STAFF REPORT

SHORELINE SUBSTANTIAL DEVELOPMENT PERMIT

Project No.:	SHL22-019
Description:	A request for a Shoreline Substantial Development Permit with SEPA Review to demolish an existing shared pier, remove (23) existing piles, relocate (7) existing boatlifts, relocate one existing dual jet ski lift, install (2) new dual jet ski lifts, install one new personal watercraft (PWC) lift, removed one existing dock mounted PWC lift, drive (30) 8-inch steel piles, (12) 12-inch steel piles, install one platform lift, and construct a new 1106 sq ft dock with grated decking.
Applicant / Owner:	Dray Davick (Seaborn Pile Driving Co.) / Charles Jemley (signing member for community dock)
Site Address:	770X SE 58th St, Mercer Island, WA 98040; King County Assessor tax parcel number 294890TRCT.
Zoning District:	Single Family Residential (R-8.4)
Staff Contact:	Molly McGuire, Planner
Exhibits:	<ol style="list-style-type: none">1. Development Application, received by the City of Mercer Island on September 1, 20222. Revised Development Plan Set, dated February 21, 2023 and received April 24, 20233. Project Narrative, received September 1, 20224. SEPA Checklist, received September 1, 20225. No Net Lo

# PROPOSED CONDITIONS

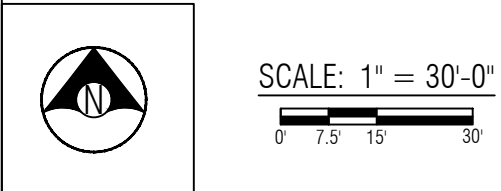
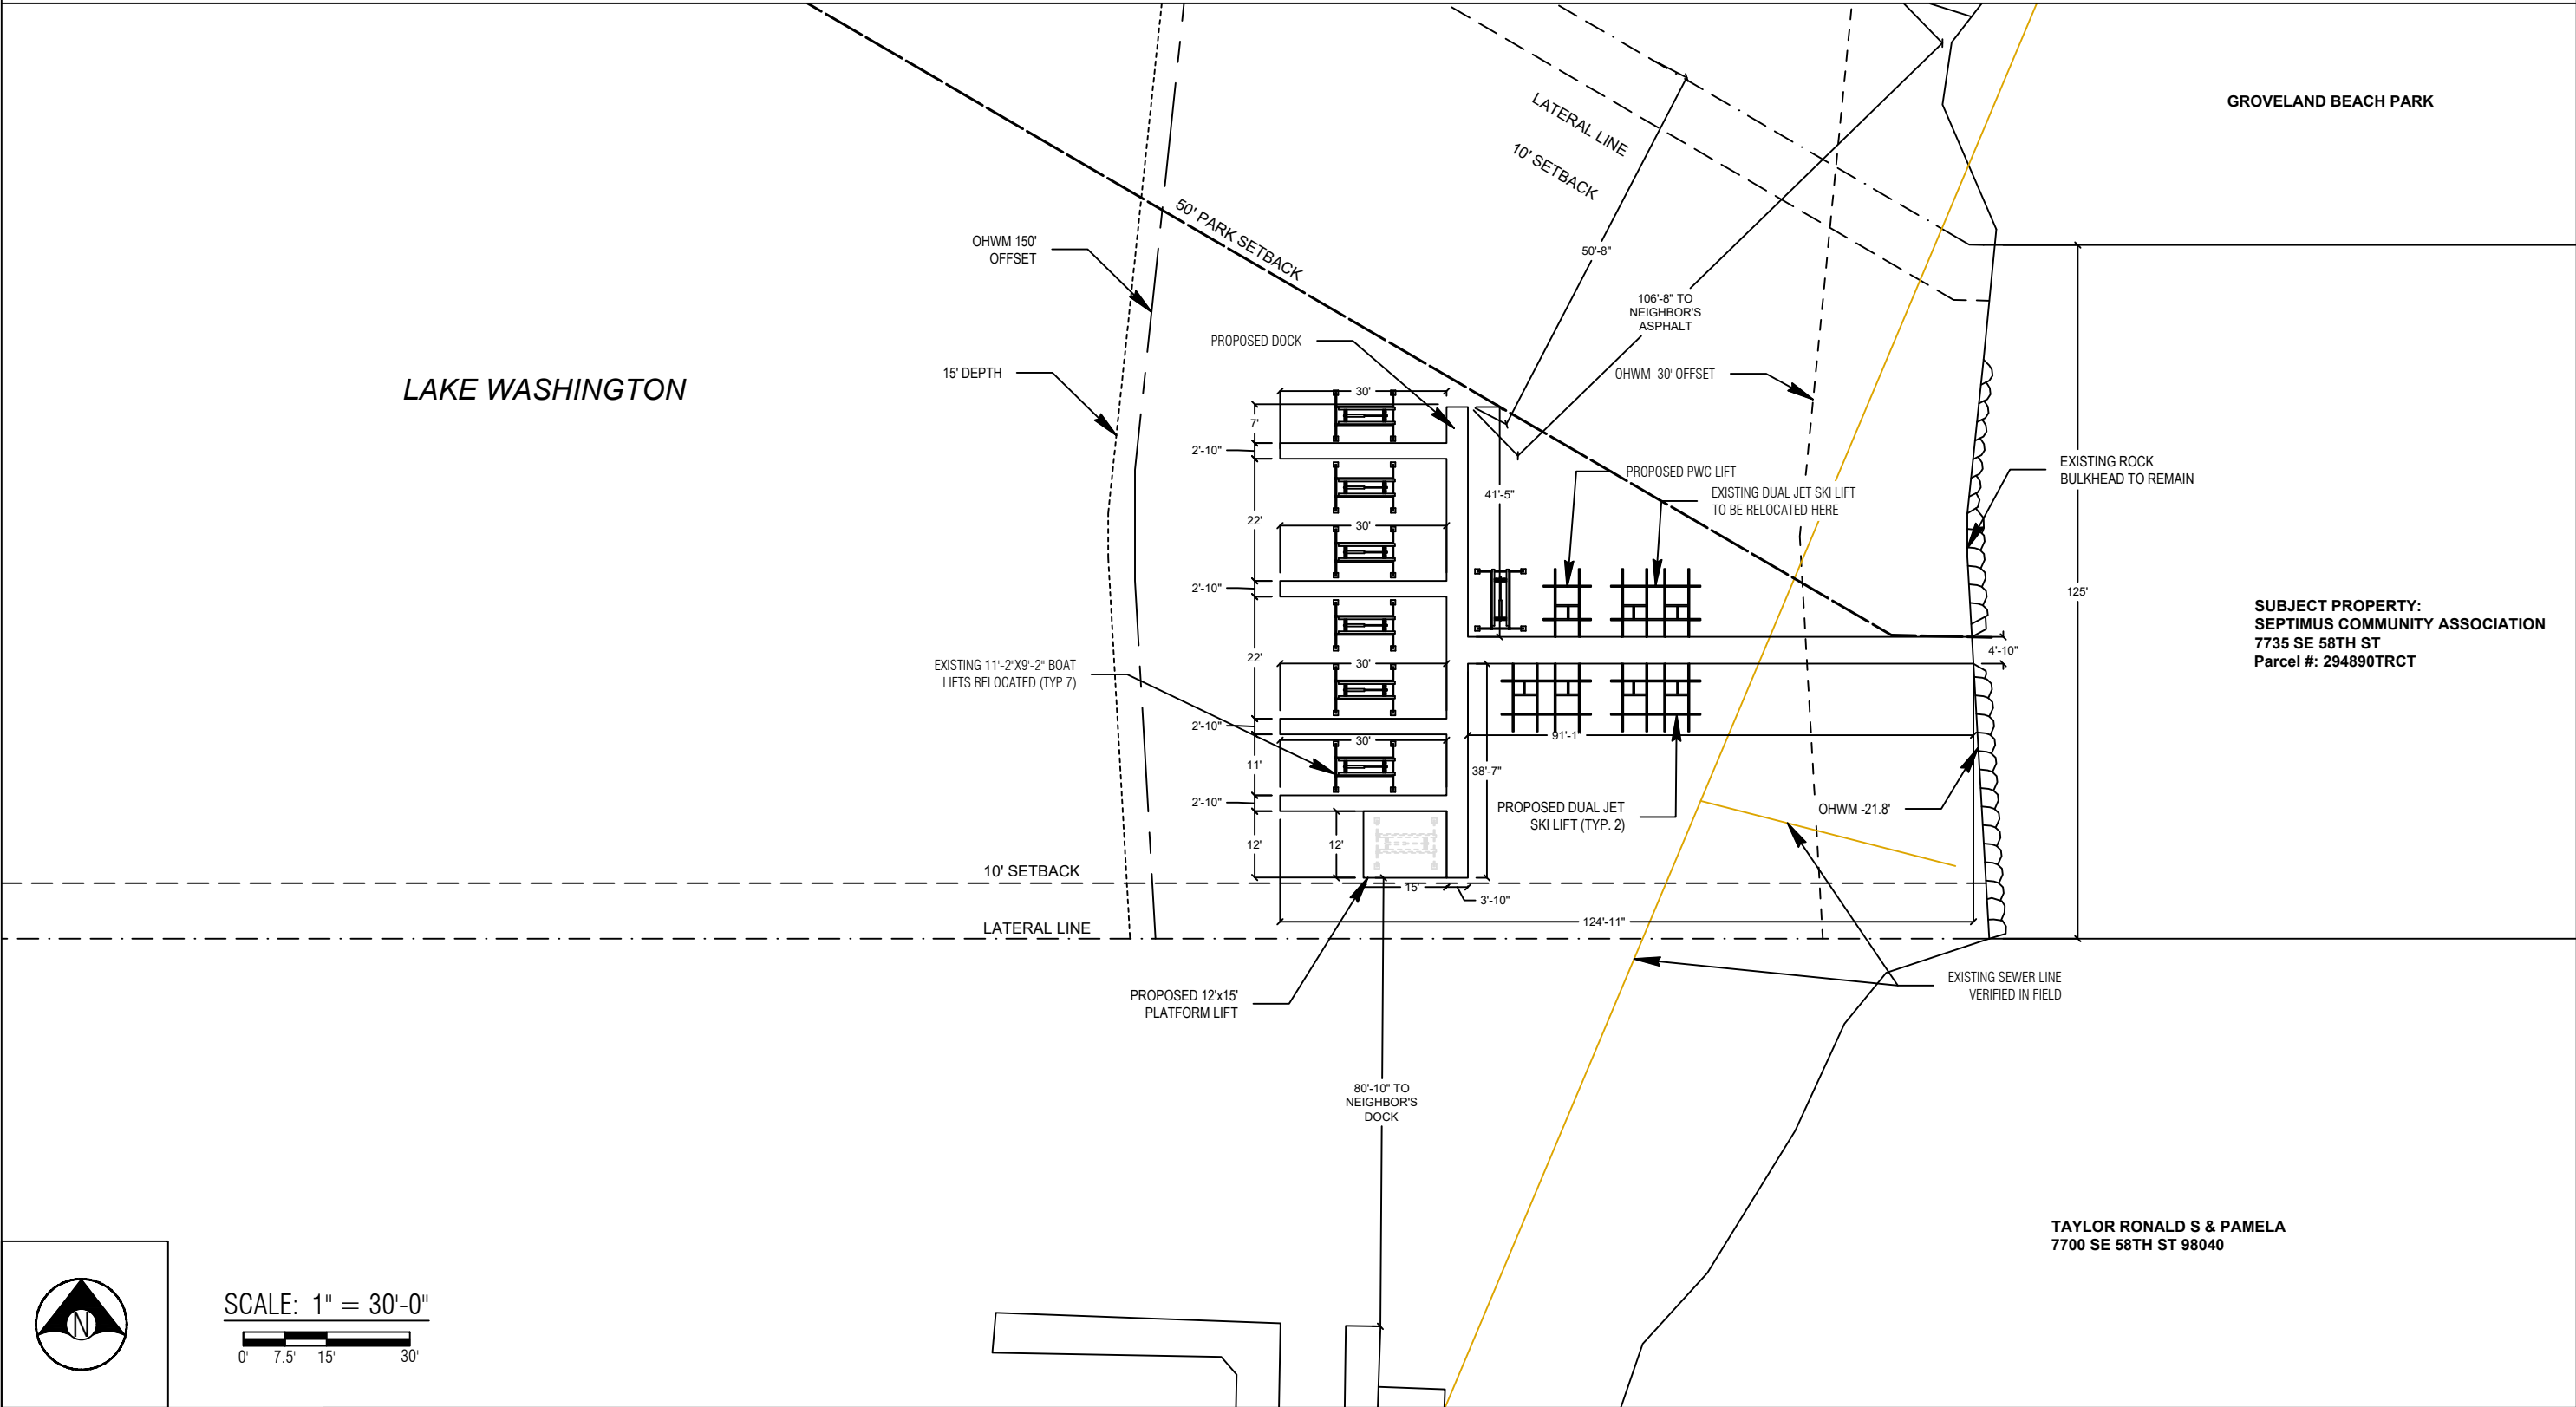
Staff Analysis: The proposed moorage facility is greater than 10 feet from the lateral line at the south lateral line sharing a common boundary with a residential property (**Exhibit 2, Sheet A3.0**); therefore, this requirement is met.

Staff Analysis: The proposed moorage facility is greater than 50 feet from the lateral line at the north lateral line sharing a common boundary with the urban park environment (**Exhibit 2, Sheet A3.0**); therefore, this requirement is met.

Staff Analysis: The proposed moorage facility would be 4 feet 10 inches wide within 30 feet waterward of the OHWM (**Exhibit 2, Sheet A3.0**). The applicant has provided documentation that a resident of a property utilizing the semi-private recreational tract has a documented permanent state disability as defined in WAC308-96B-010(5) (**Exhibit 6**); therefore, the proposed dock width meets this requirement.

Staff Analysis: The proposed moorage facility would not be greater than 6 feet wide more than 30 feet waterward from the OHWM (**Exhibit 2, Sheet A3.0**).

Staff Analysis: The subject tract has a water frontage of 125 feet (**Exhibit 2, Sheet A3.0**); therefore, this requirement is met.

**SHEET**  
**A7.0**

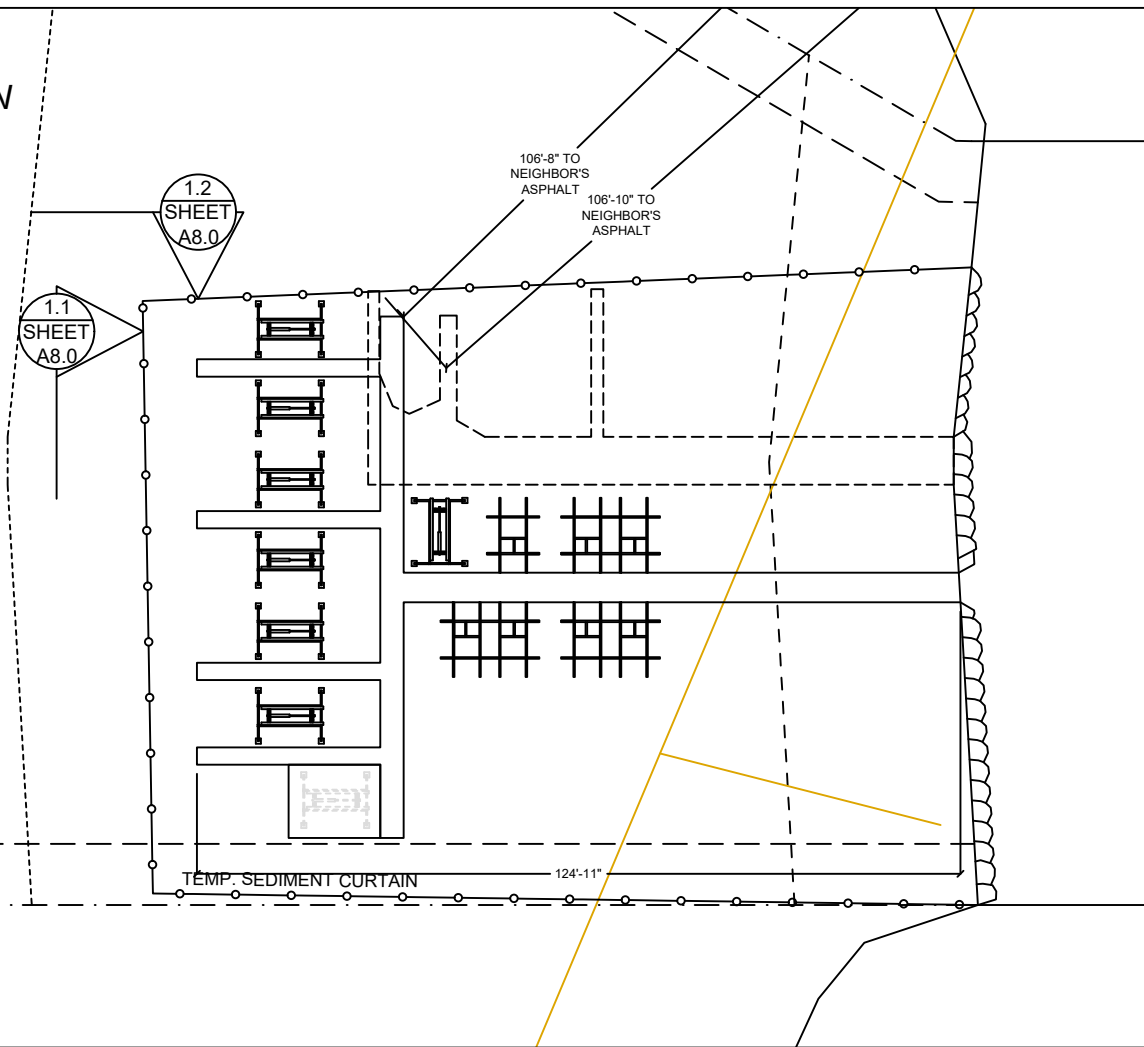
Staff Analysis: The proposed moorage facility extends 124 feet 11 inches waterward from the OHWM to a water depth of 11.85 feet (**Exhibit 2, Sheet A7.0**); therefore, this requirement is met.

# HARDSCAPE CALCULATION EXISTING/PROPOSED

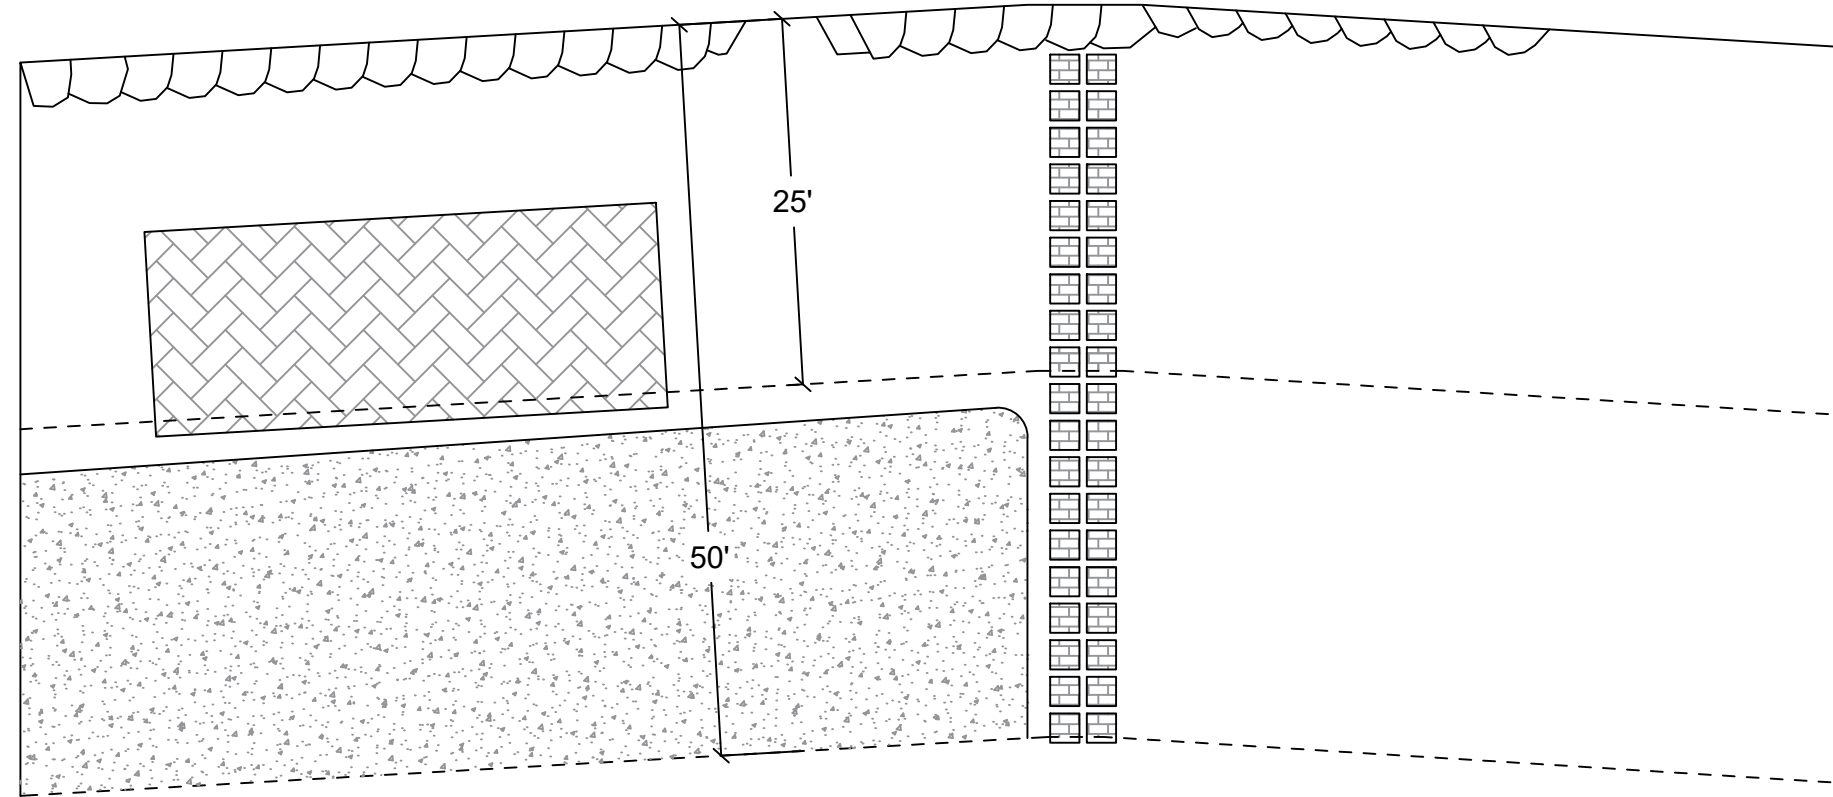
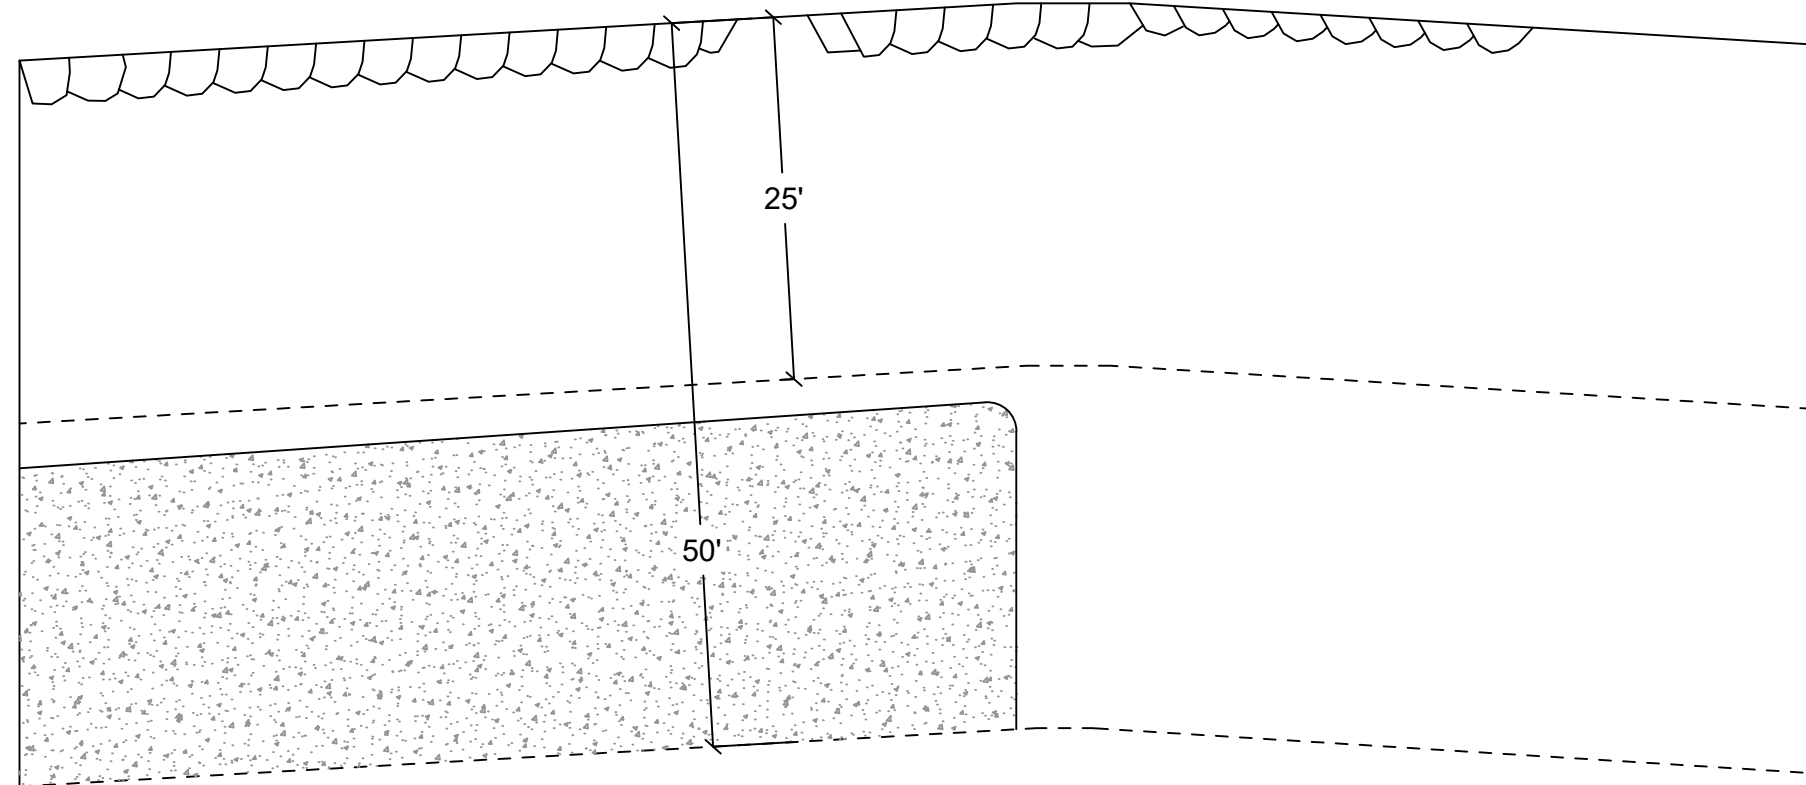
Staff Analysis: The proposal does not include structures within 25 feet from the OHWM. The existing parking area is located greater than 25 feet from the OHWM (**Exhibit 2, Sheet A15.0**); therefore, this requirement is met.

Staff Analysis: The subject property contains an existing patio, walkway, and parking area within 25 and 50 feet from the OHWM. The proposal includes the removal of 525 square feet of hardscape within 0-25 feet from the OHWM and 117 square feet of hardscape within 25-50 feet from the OHWM. The existing parking area within 25-50 feet from the OHWM is legally nonconforming per MICC 19.13.020(A) and is allowed to continue.

The proposal results in 7.6 percent of hardscape within 0-25 feet from the OHWM and 49 percent of hardscape and lot coverage within 25-50 feet from the OHWM due to the legally nonconforming parking area (**Exhibit 2, Sheet A15.0**); therefore, this requirement is not met and allowed to continue.
